**Addendum No. 1**

RE: Contract ID: C202039

**Edgecombe County (B-2965)**

Bridge Over Tar River and Approaches On US-64 Business and NC-33  
From US-258, NC-111 and NC-122 To SR-1308

REVISIONS						SHEET NO.
NO.	BY:	DATE:	NO.	BY:	DATE:	S-1
1			3			TOTAL SHEETS
2			4			48

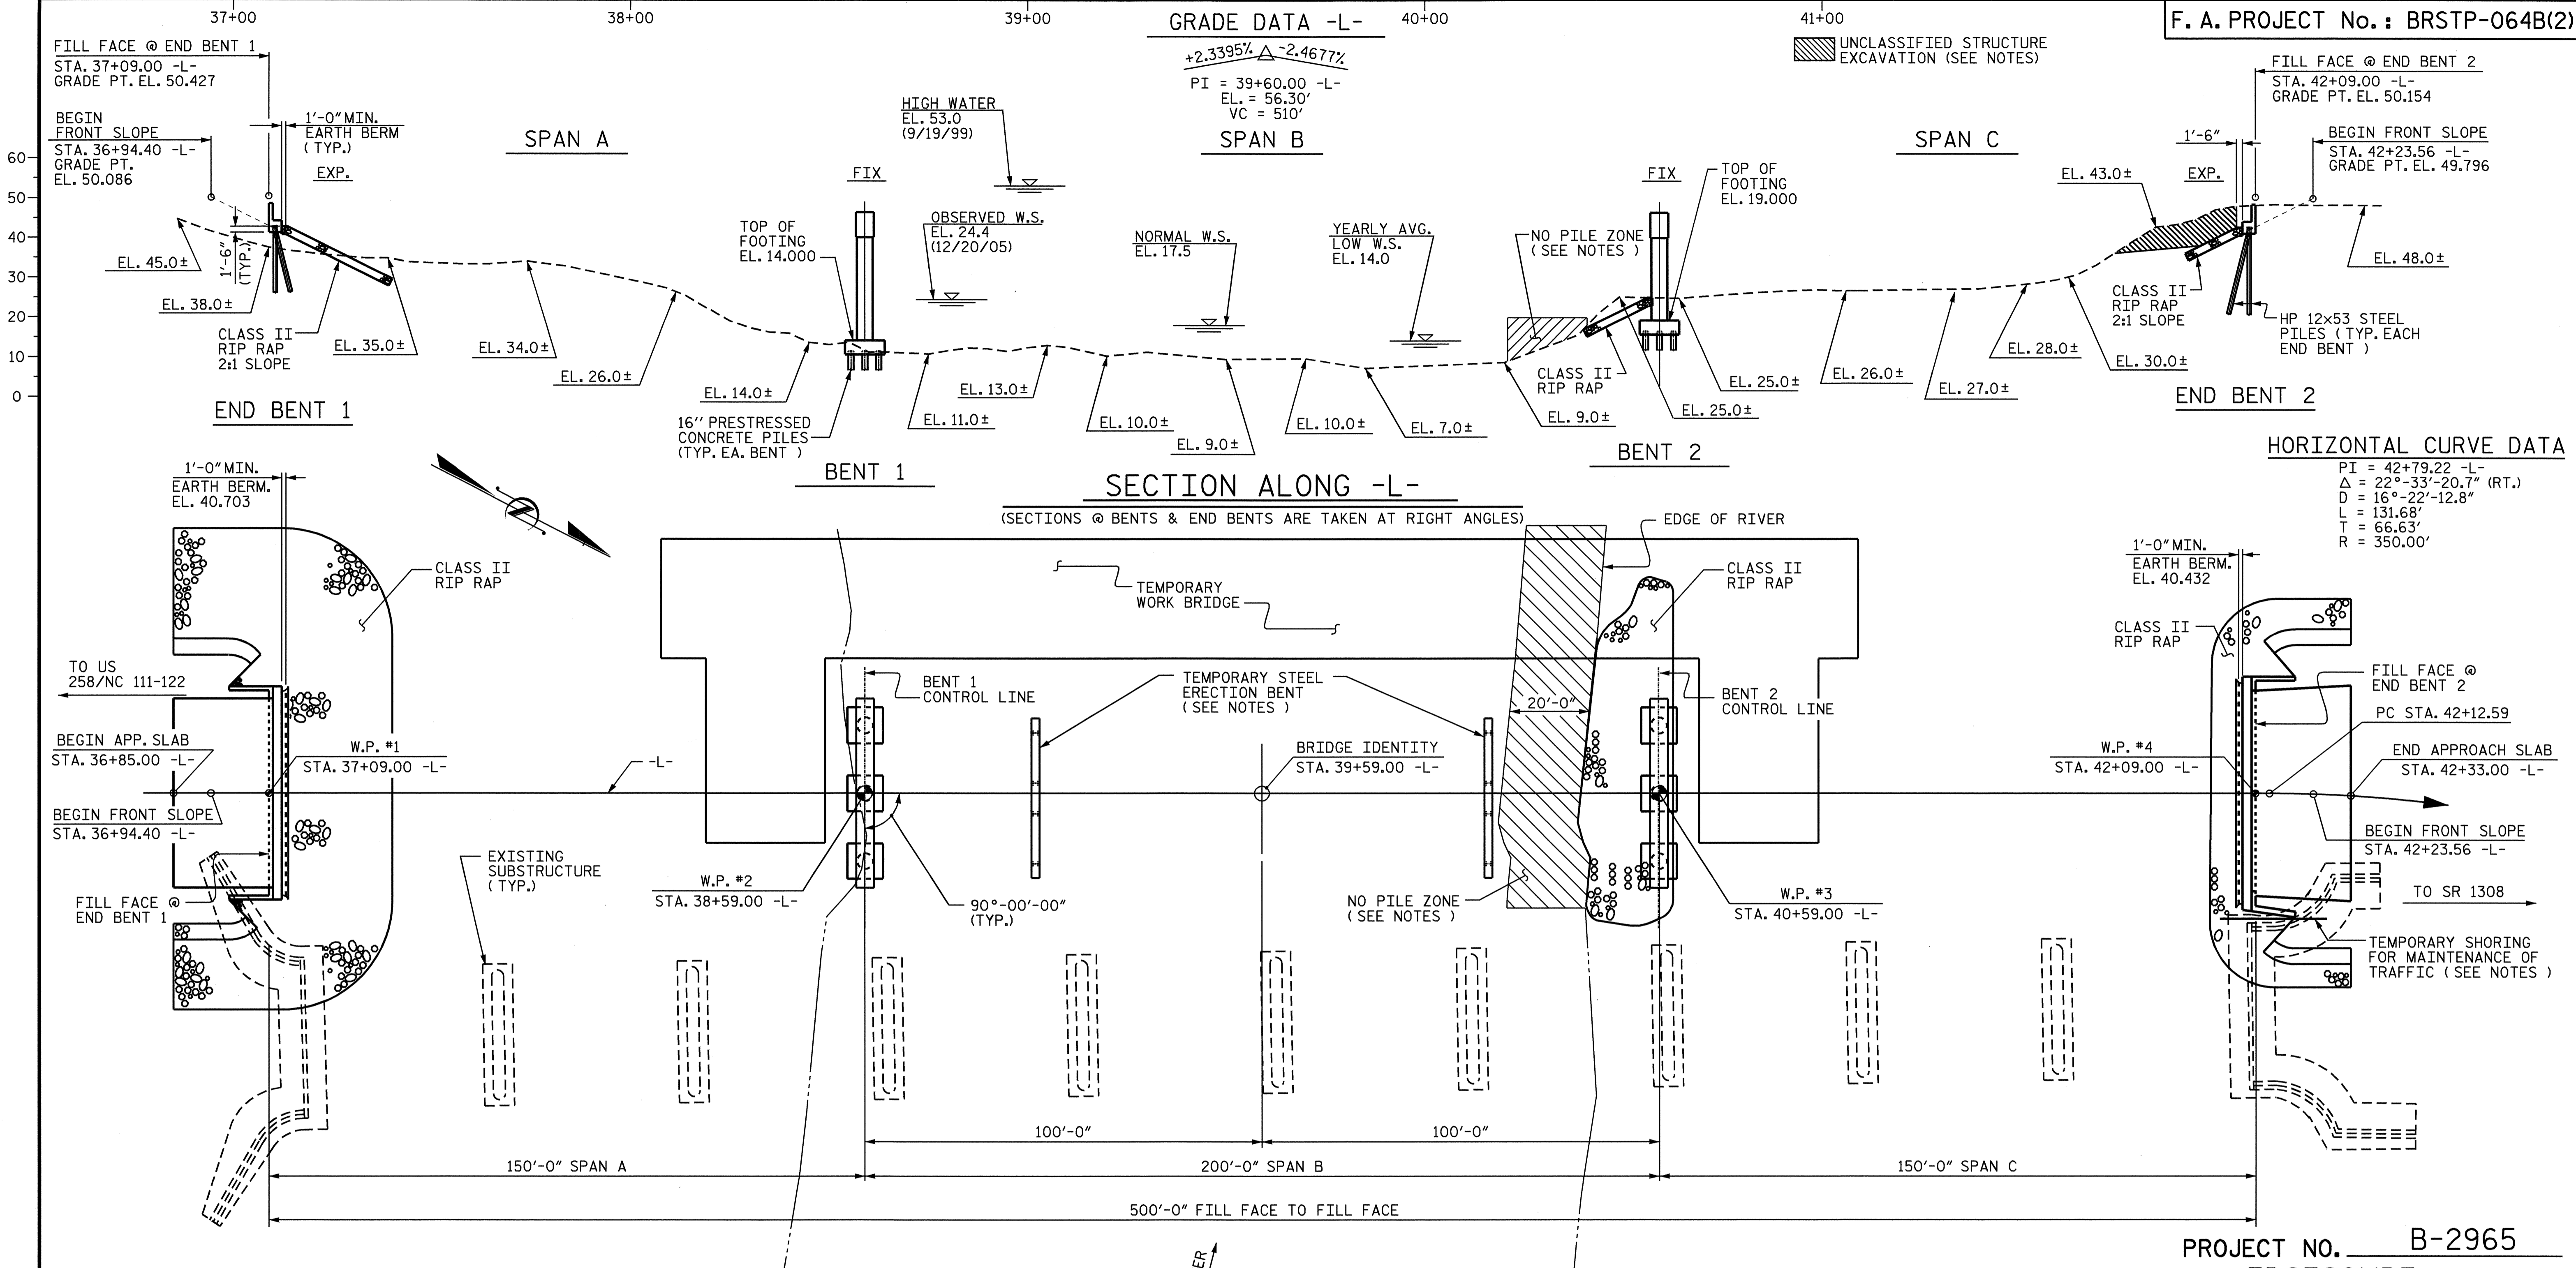
On Sheet Nos. S-1 and S-3 a revision has been made concerning the note for the "No Pile Zone". Please void Sheet Nos. S-1 and S-3 in your plans and staple the revised Sheet Nos. S-1 and S-3 thereto.
